**Addendum No. 3**

RE: Contract # C204739

**Graham County (A-0009CB)**

NC 143 FROM SR 1223 (BEECH CREEK ROAD) TO 0.5 MILES NORTH OF APPALACHIAN TRAIL.

SHEET NO. S-1
 TOTAL SHEETS 6

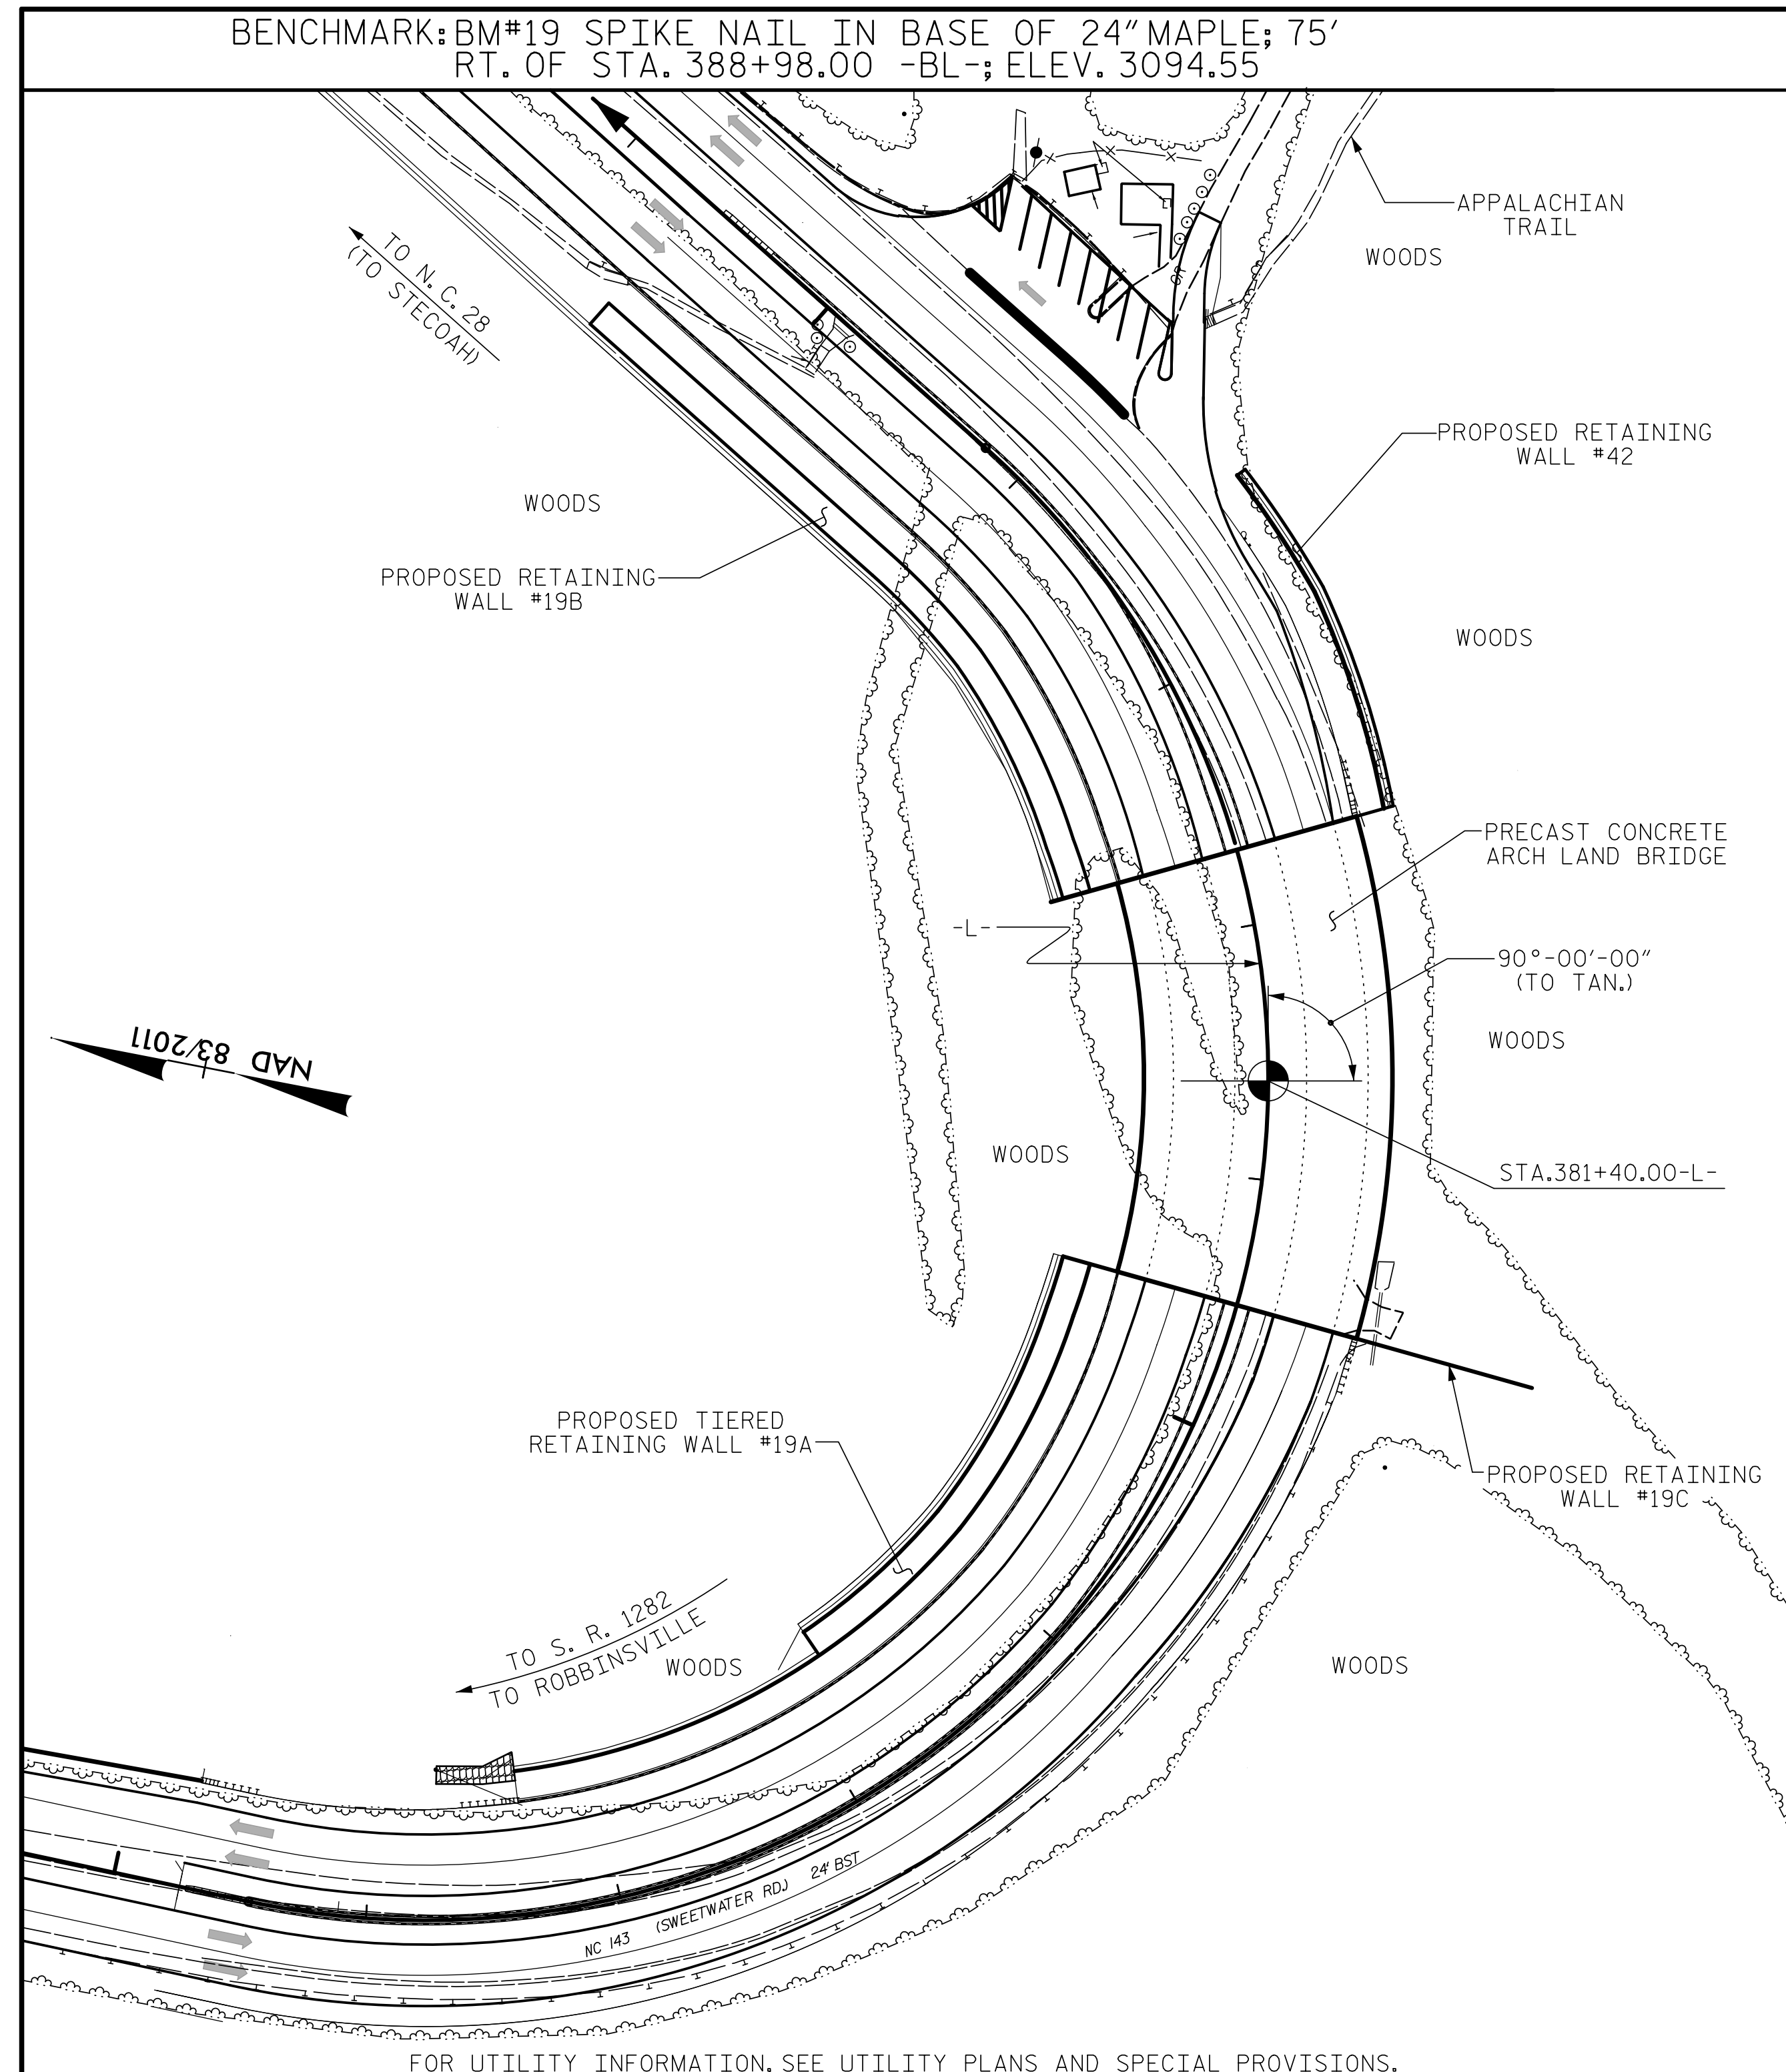
Sheet No.	Revision
S-1	Added Note: All Precast Concrete Arch Units shall be installed in place before any fill can be placed on the units.
S-3	Added a minimum 6" dimension from the top of parapet to the proposed fill.
